Date 13th January 2021

Town and Country Planning Act 1990 as amended
Oxford Retail Park, Ambassador Avenue, Oxford
Section 73 application to amend elevational details, Oxford Retail Park, ref 19/03236/FUL

2020 Drawing Number: 1877-PL05

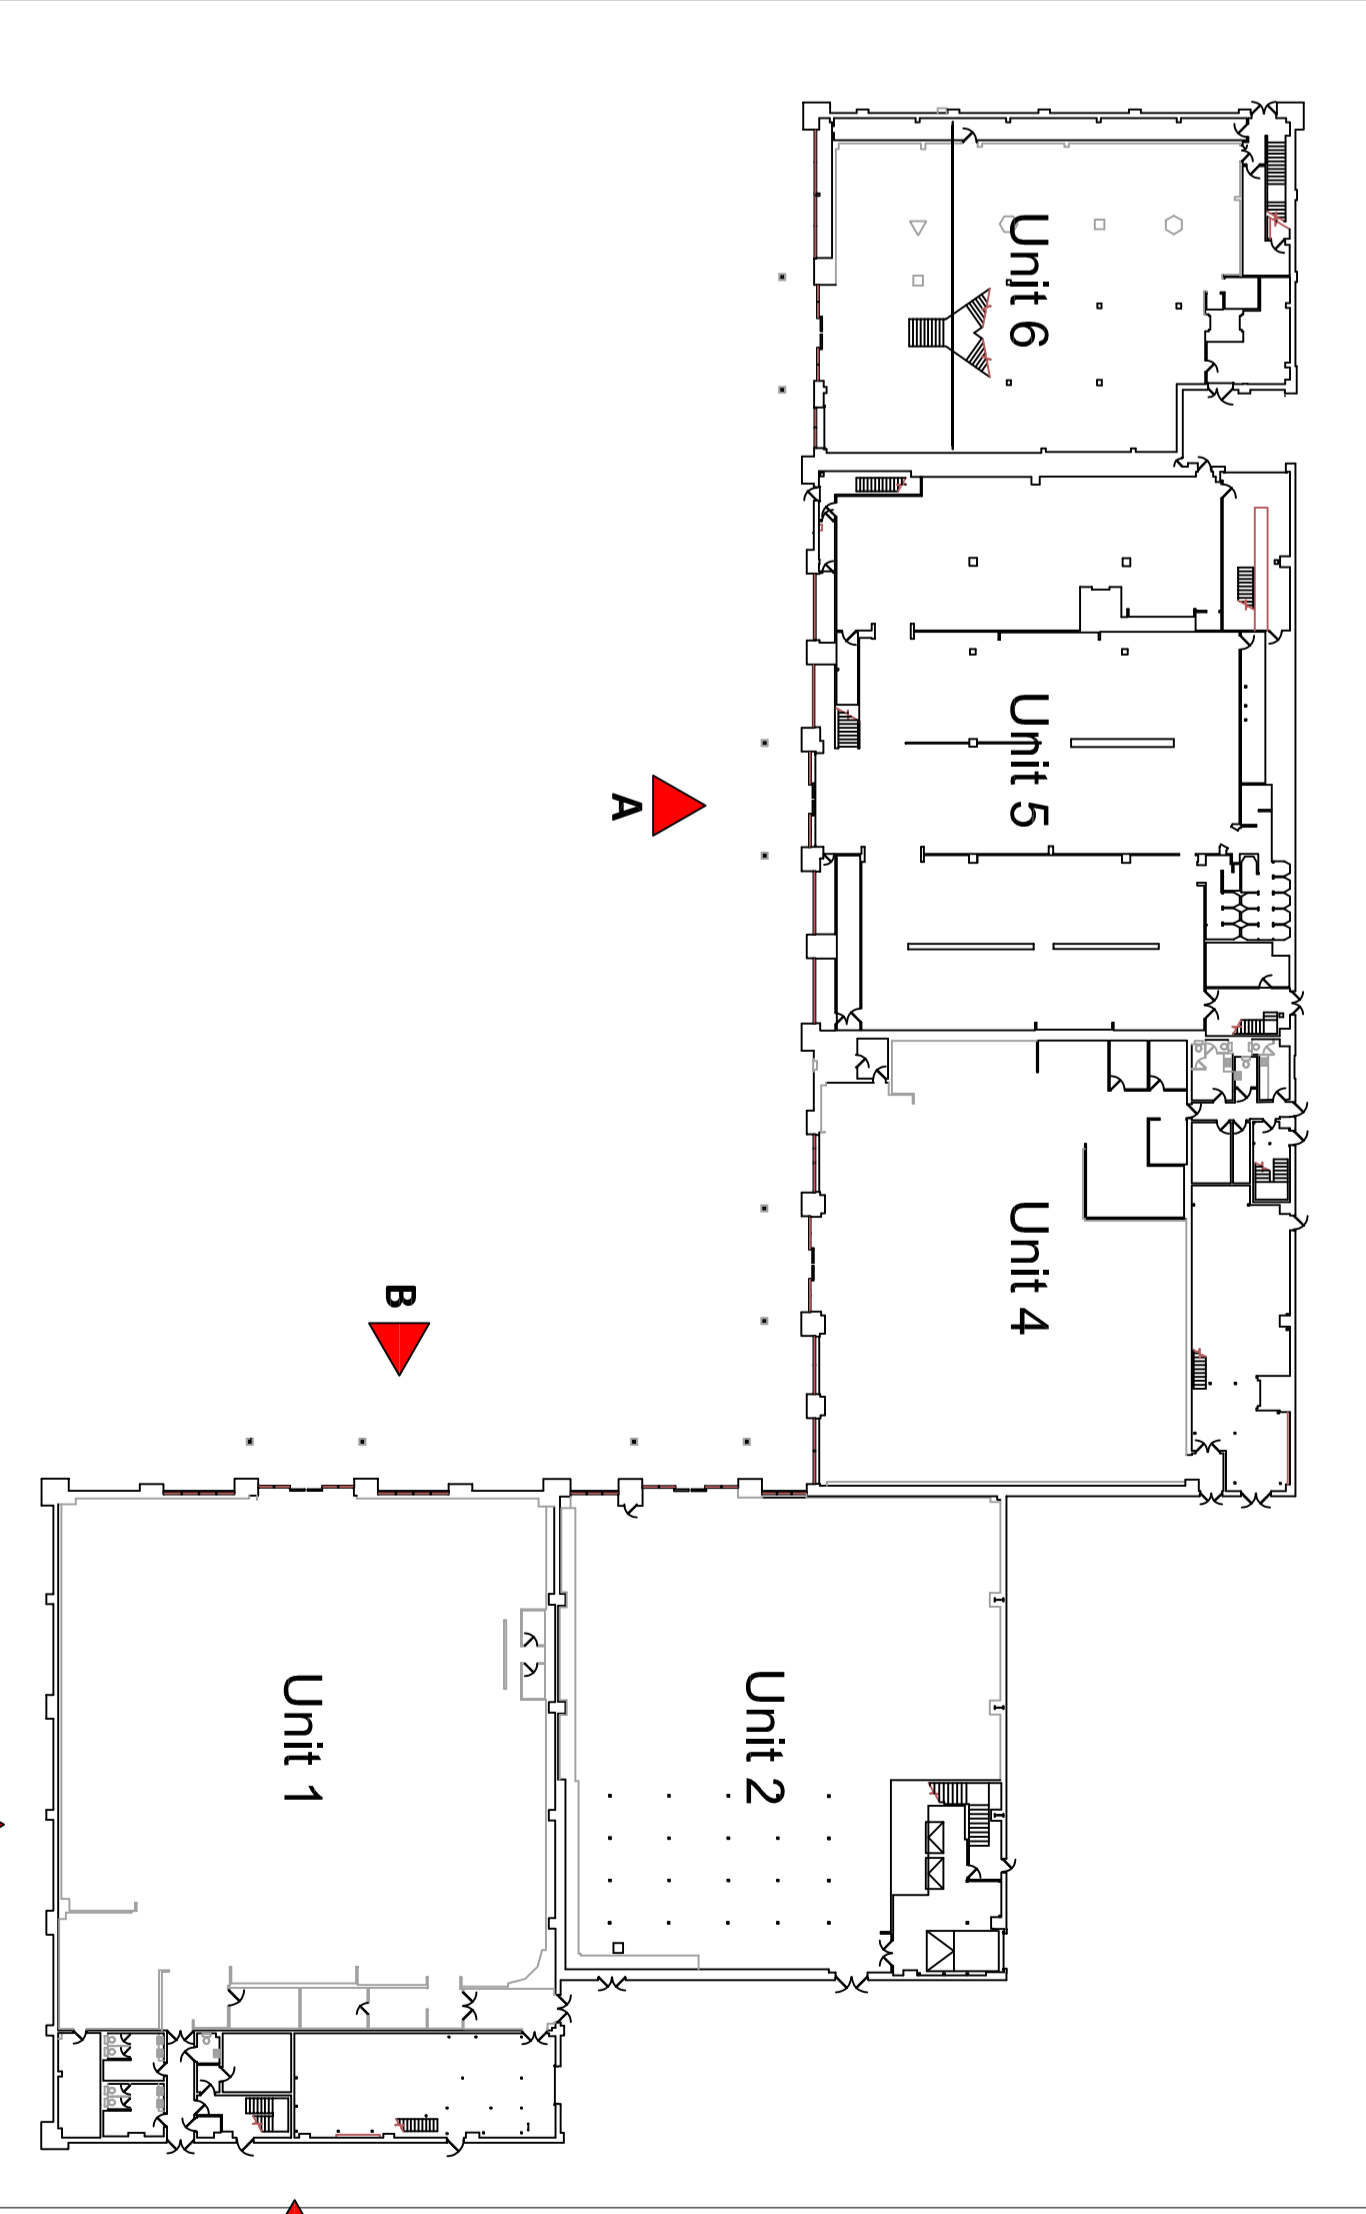
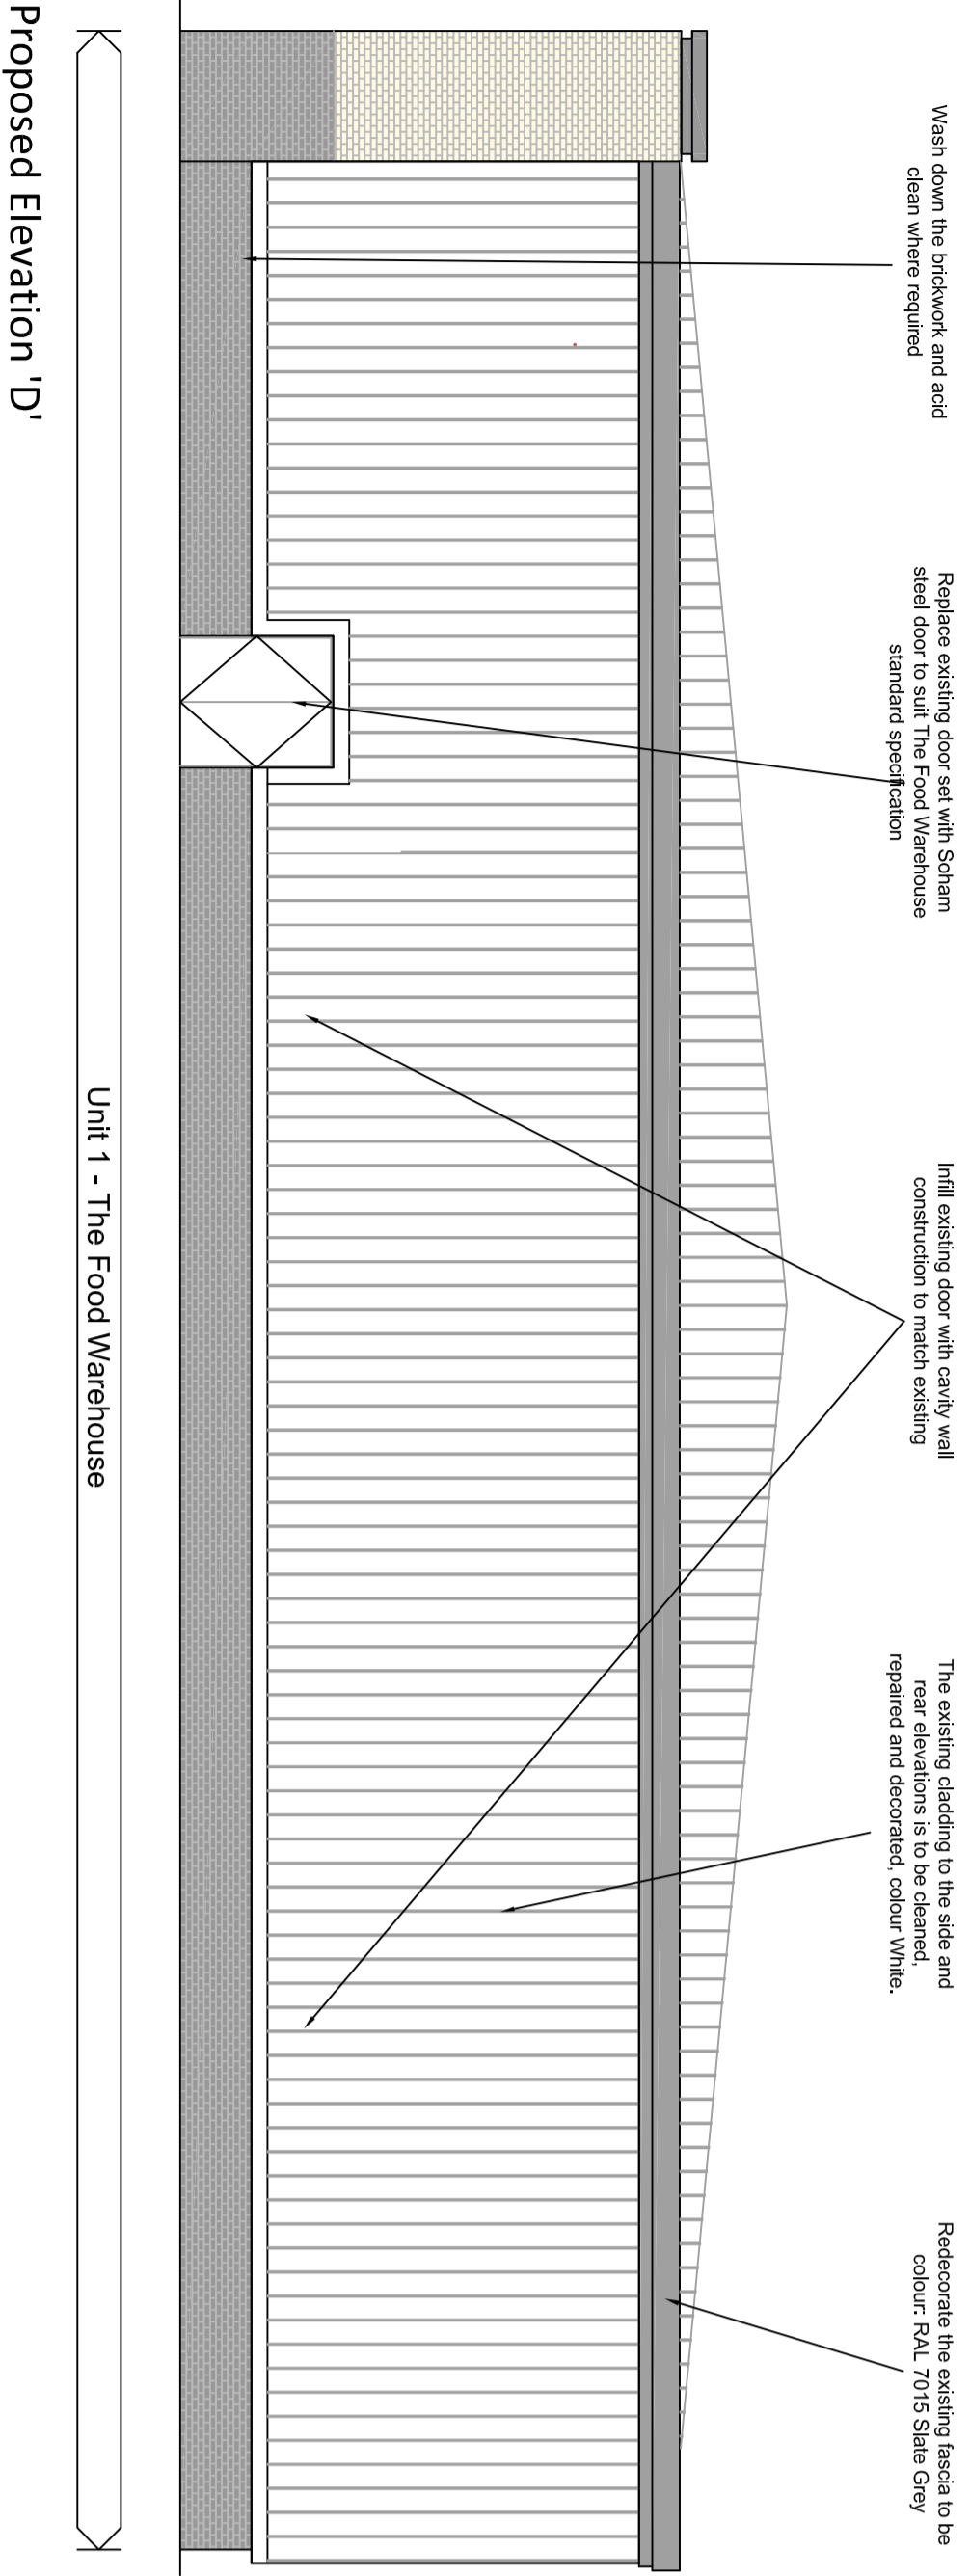
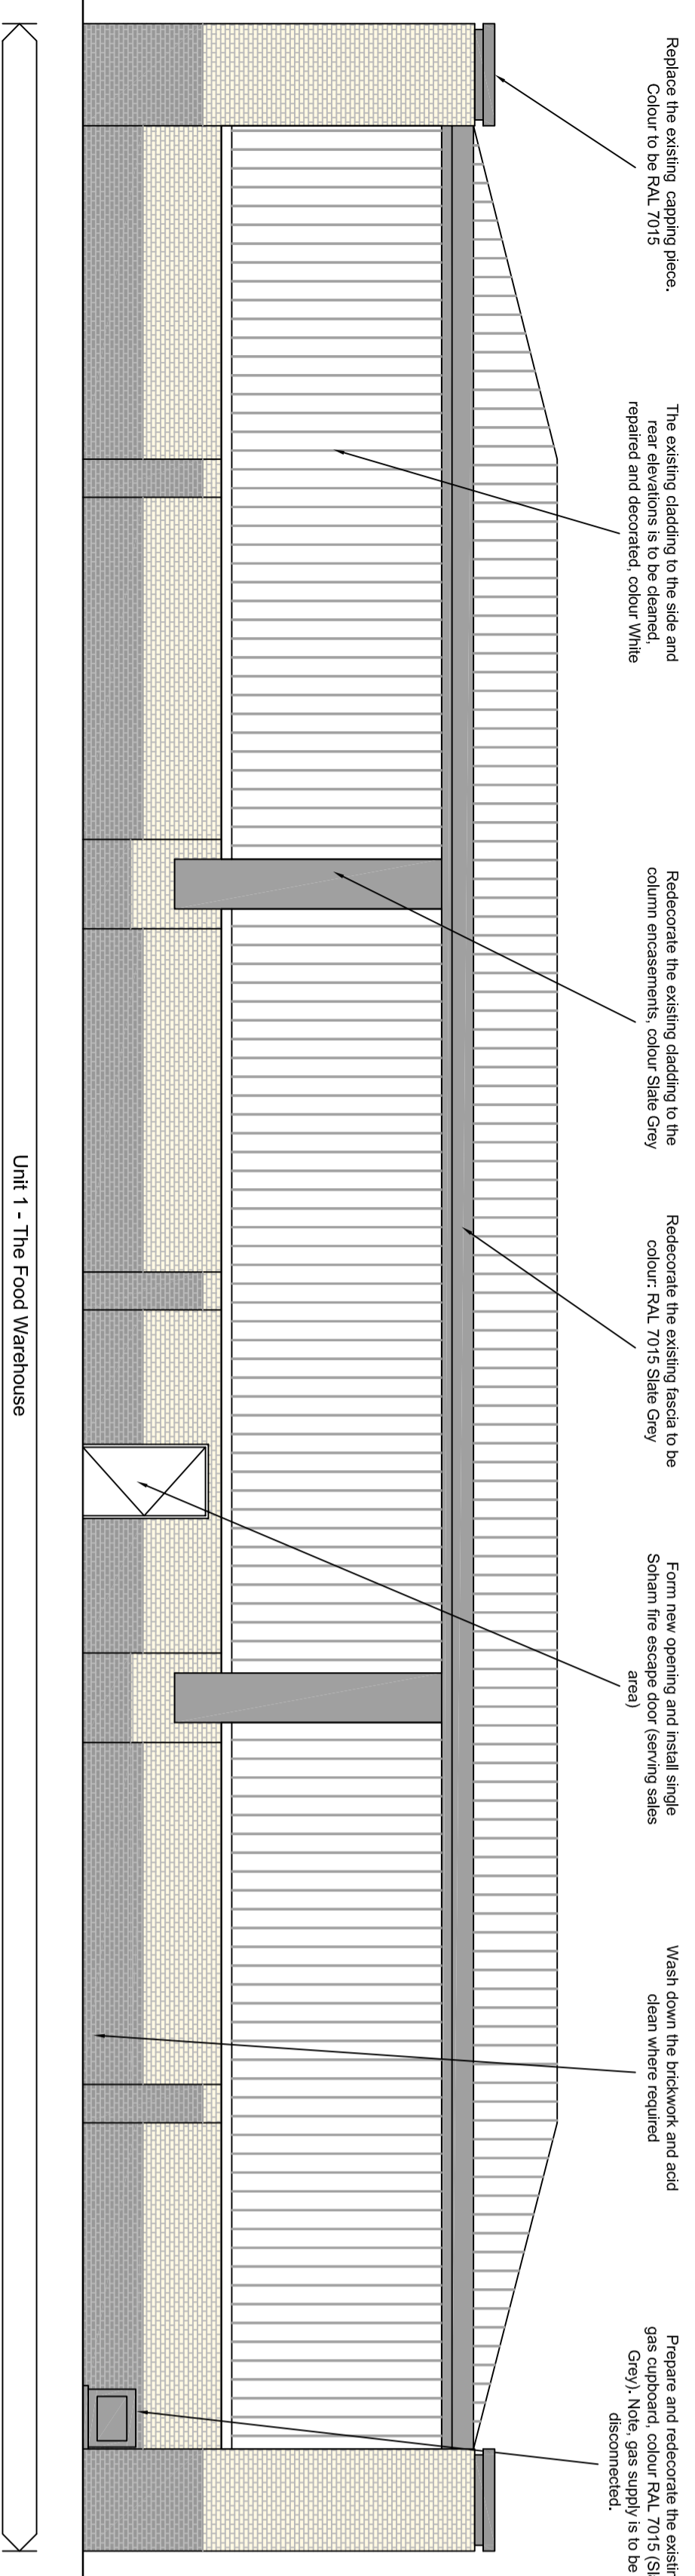
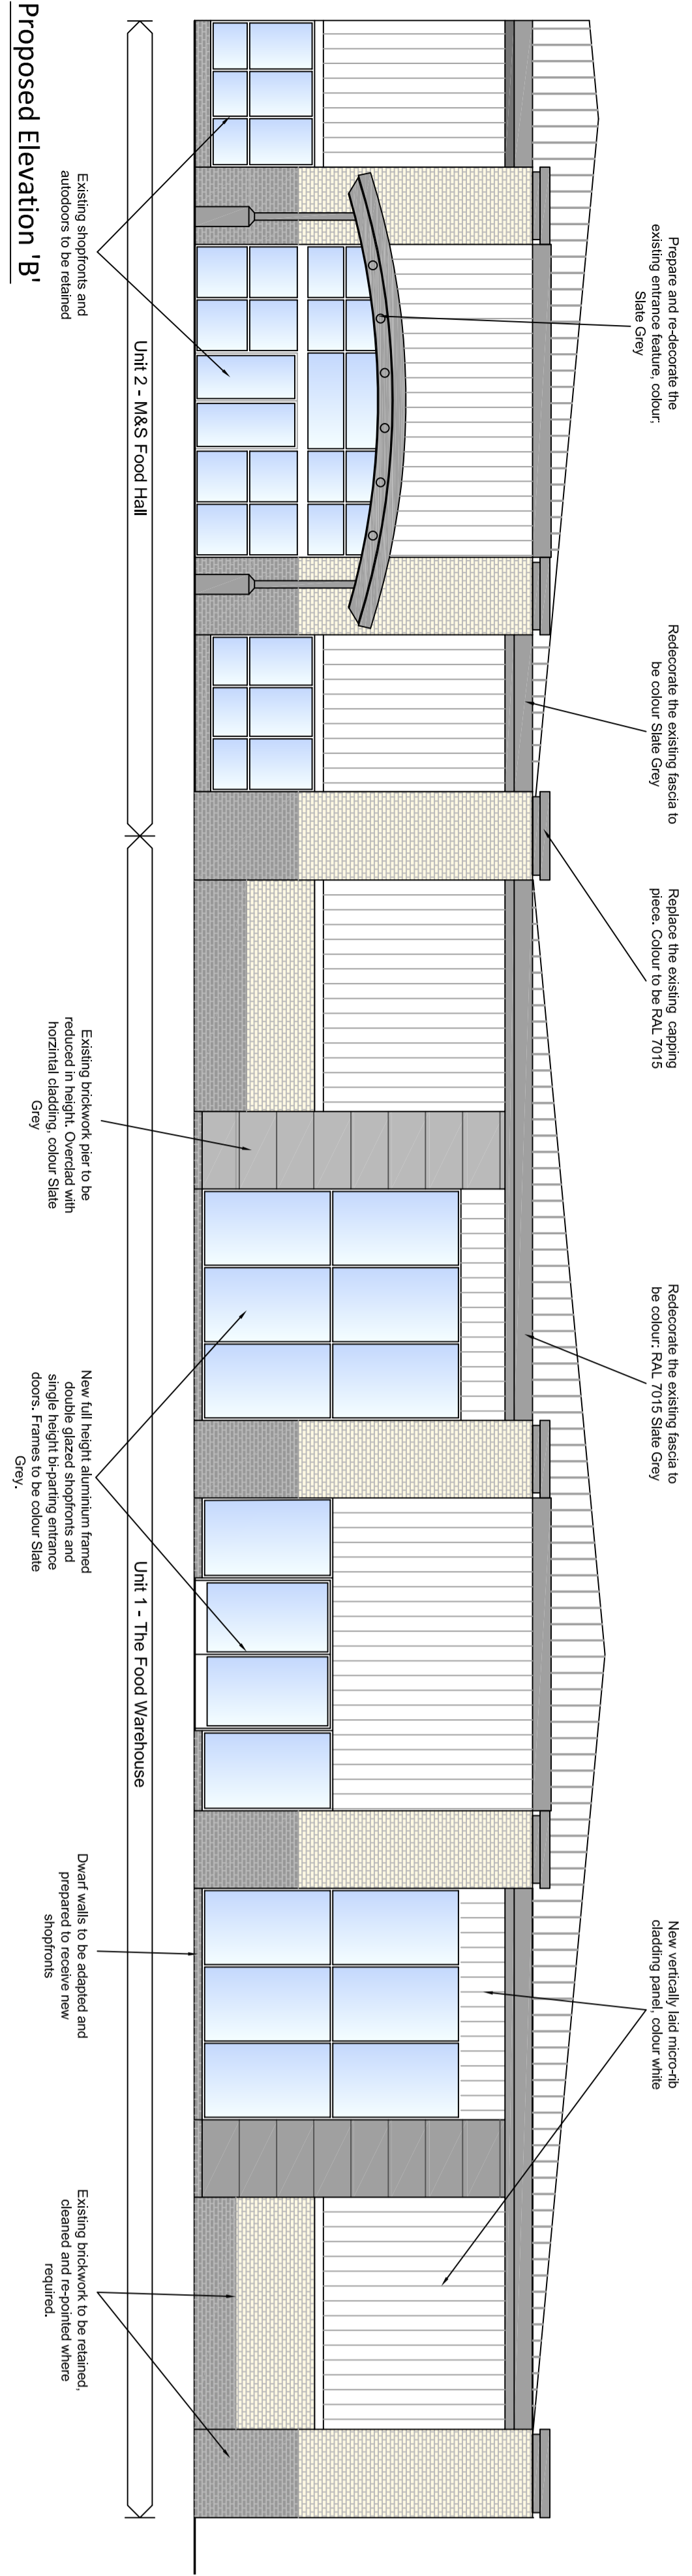
1. New vertical cladding specification to the front elevations – I have attached a photo showing the proposed material. Note, these are shown in a horizontal configuration, but we will be laying them vertically. The colour will be RAL 9003 (Signal White);

2. The previously shown new glazing to M&S, Boots and Next is omitted. Their existing glazing is to remain;
3. The entrance features to M&S, Boots and Next are to remain as existing and be redecorated RAL 7015 (Slate Grey);

4. The existing fascia is to be retained and redecorate RAL 7015 (Slate Grey);
5. The external 'columns' currently shown proposed clad in a horizontally laid cladding panel are altered to have the new cladding panel at the upper level only. This avoids having to adjust the existing brickwork at low level thus causing disruption to the trading Tenants. The colour of this cladding will be RAL 7015 (Slate Grey);

6. The proposed glazing and cladding arrangements to the former Mothercare have been amended to suit the incoming Tenants requirements;
7. New fire escape door on the side elevation of the former Mothercare (elevation C); and

8. Infilling of redundant fire escape doors to the rear of the former Mothercare (elevation D).

The latest proposed cladding as shown on our drawings is a 300mm wide micro-rib panel which will be vertically laid as previously shown. The only variation over the Mountford Pigott's drawings is the panel width (previously shown as circa. 1000mm wide). The cladding profile and colour remains the same.
